**WELWYN HATFIELD BOROUGH COUNCIL  
EXECUTIVE DIRECTOR - PLANNING, PUBLIC PROTECTION AND GOVERNANCE**

**DELEGATED APPLICATION**

**Application No:** 6/2020/2410/HOUSE  
**Location:** 37 Sherrardspark Road Welwyn Garden City AL8 7JY  
**Proposal:** Erection of single storey rear extension, partial conversion of garage into study, internal alterations on ground and first floor and conversion of existing loft into habitable space including 4 x rear rooflights  
**Officer:** Ms Emily Stainer

DRAWING NUMBER
P/03

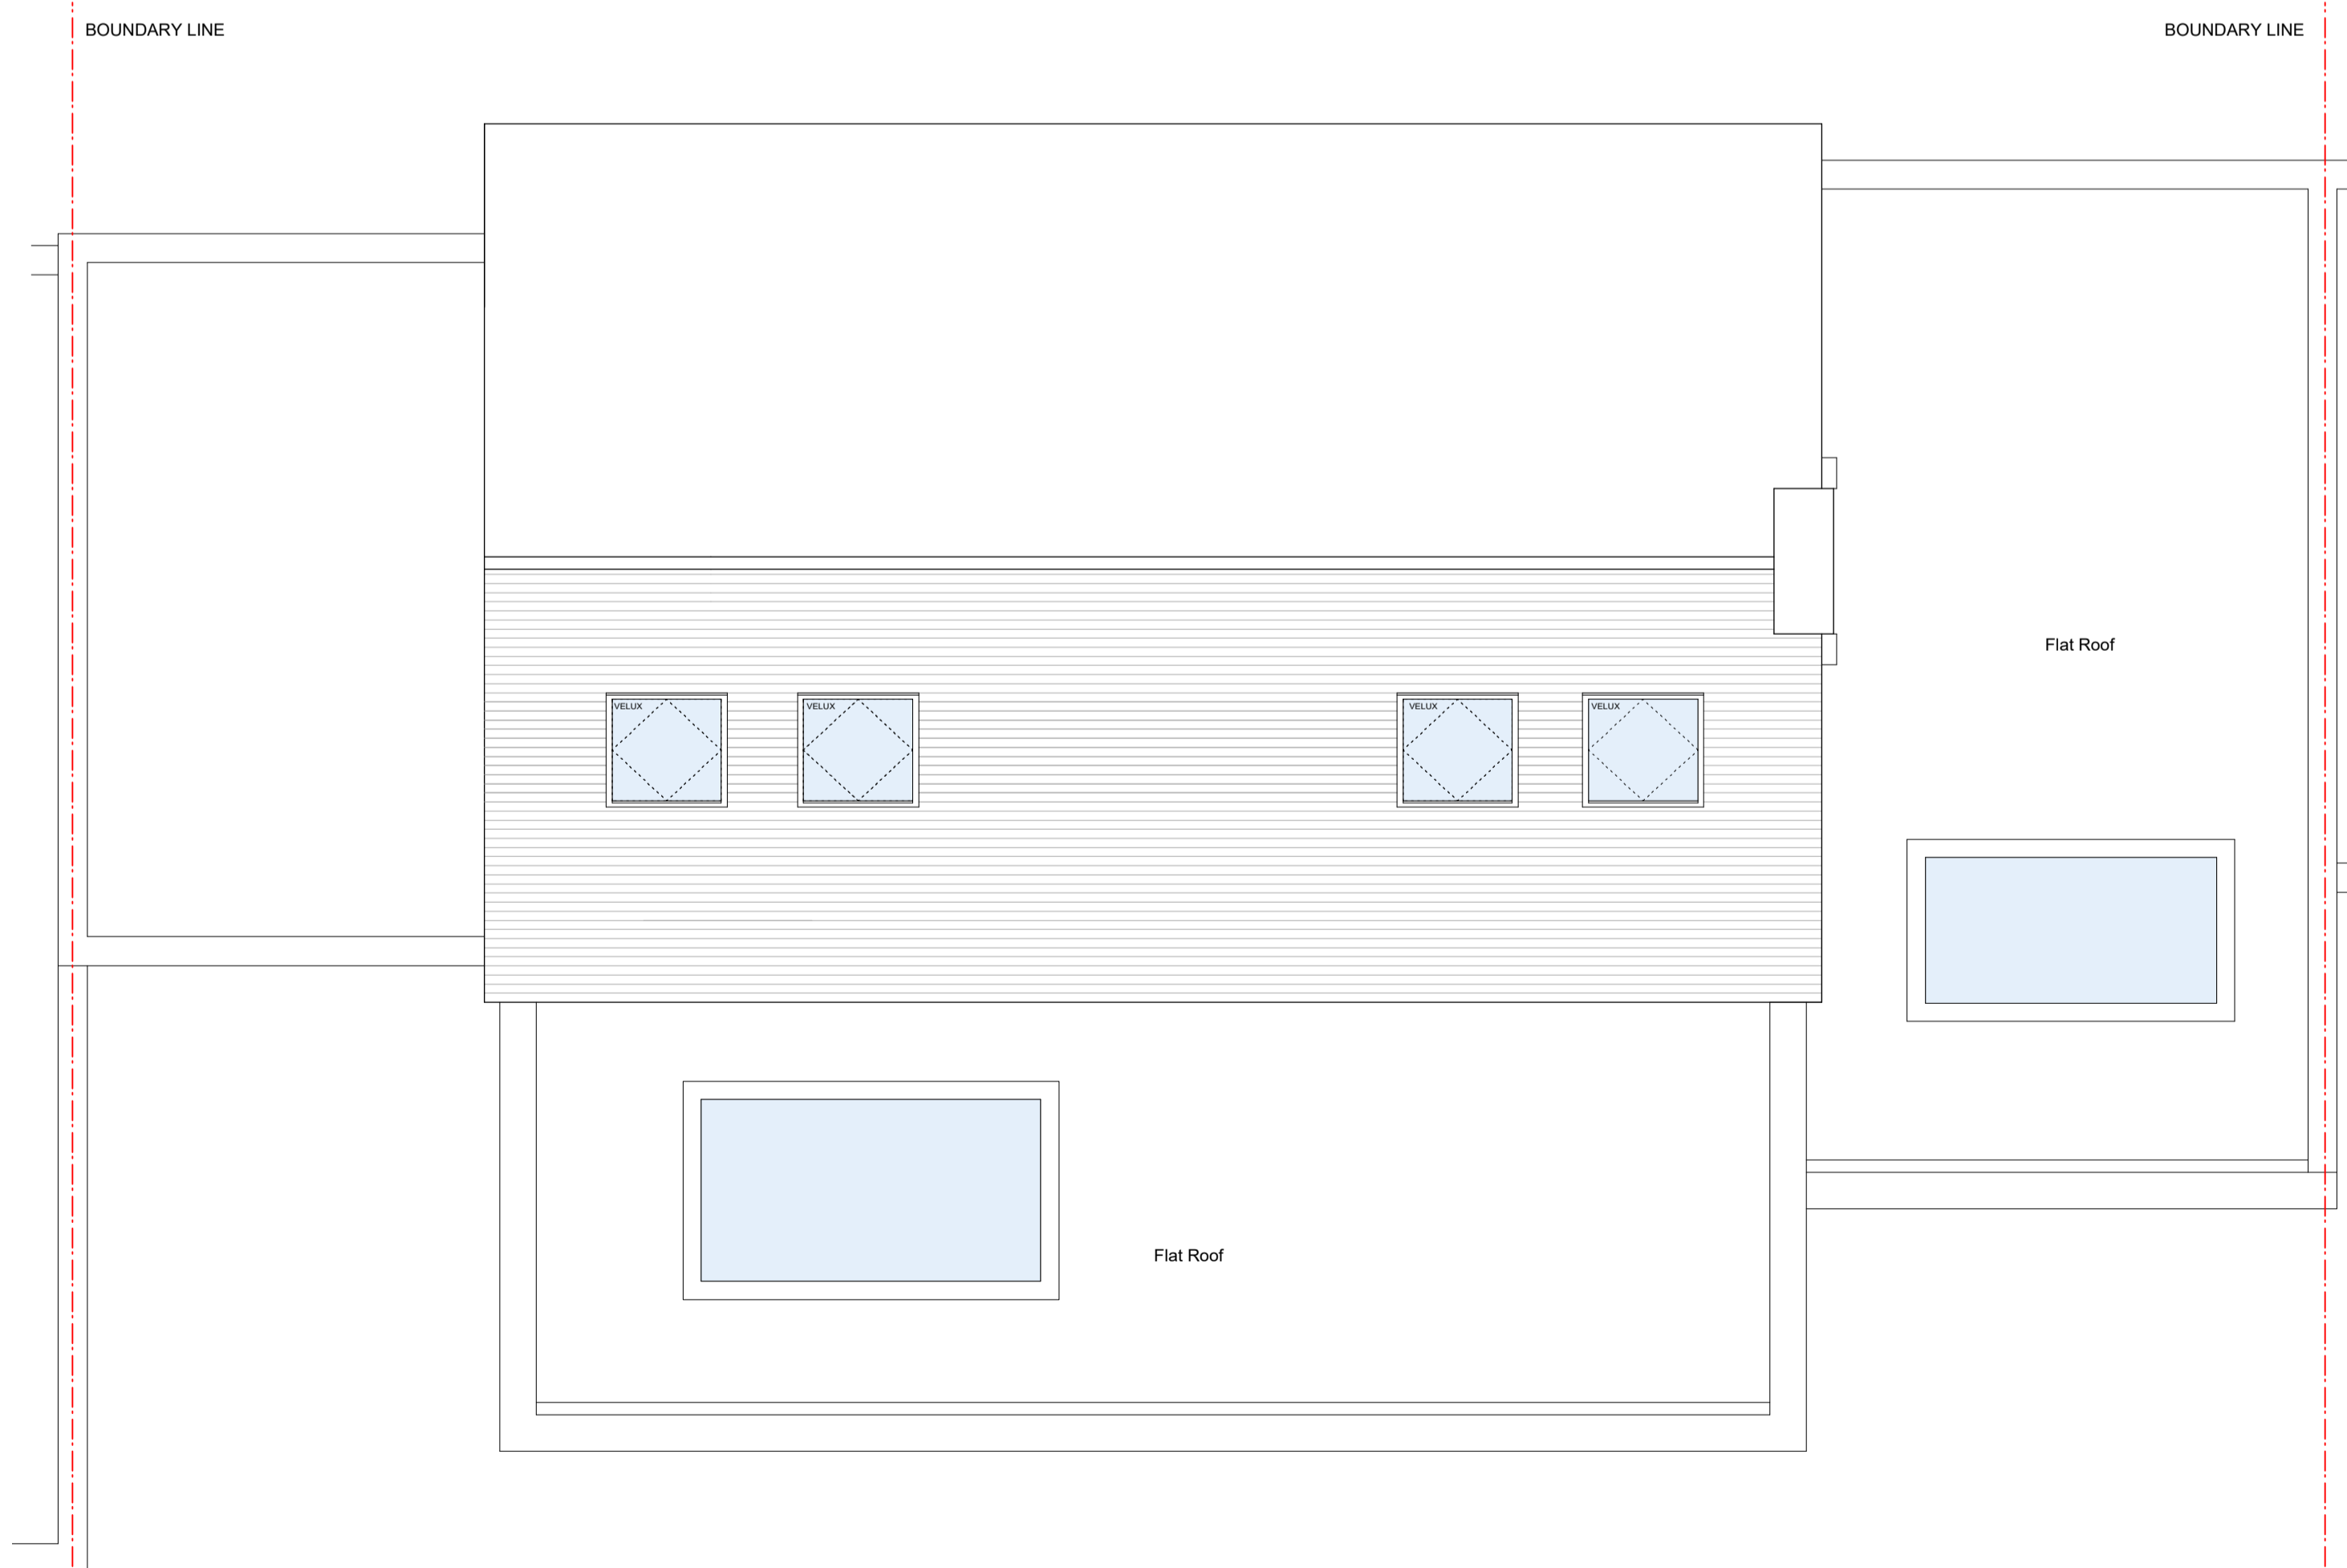
The proposed drawings have been amended during the application process to remove the front rooflight and include a flush flat roof light to the side to replace the proposed roof lantern. The proposed roof lights will be modest in size not excessively projecting from the roof slope. Given their location to the rear of the property, they would not be unduly visible from the street scene, therefore they will maintain the amenities and values of the conservation area. The proposal also involves the addition of a side gable window. This window would mirror openings on other properties in the area and provided the materials match the existing property, there is no objection raised. New ground floor windows would also be acceptable subject to the materials matching.

Whilst views from the proposed roof lights will be able to be gained into neighbouring gardens, given their siting and direction of view where there are already rear windows at this property, the proposed roof lights would not have an undue detrimental impact on the residential amenity to neighbouring properties. A side gable window is proposed on the second floor, which would serve a bedroom. In order to prevent overlooking to the occupiers of 39 Sherrardspark Road, it is considered reasonable to recommend a condition to secure the window is obscure glazed and fixed to be non-opening below a height of 1.7 metres when measured from the internal finished floor level. Consequently, the window serving the bedroom would not give rise to an undue loss of privacy. This is acceptable as it is not the primary window to the bedroom which would also feature 2 rear facing Velux rooflights. The new ground floor windows would have an acceptable impact.

2. The proposed second floor window located in the gable wall forming the side elevation hereby approved must be obscure-glazed and non-opening unless the part of the window which can be opened is more than 1.7 metres above the floor of the room in which the window is installed, and shall be retained in that form thereafter.
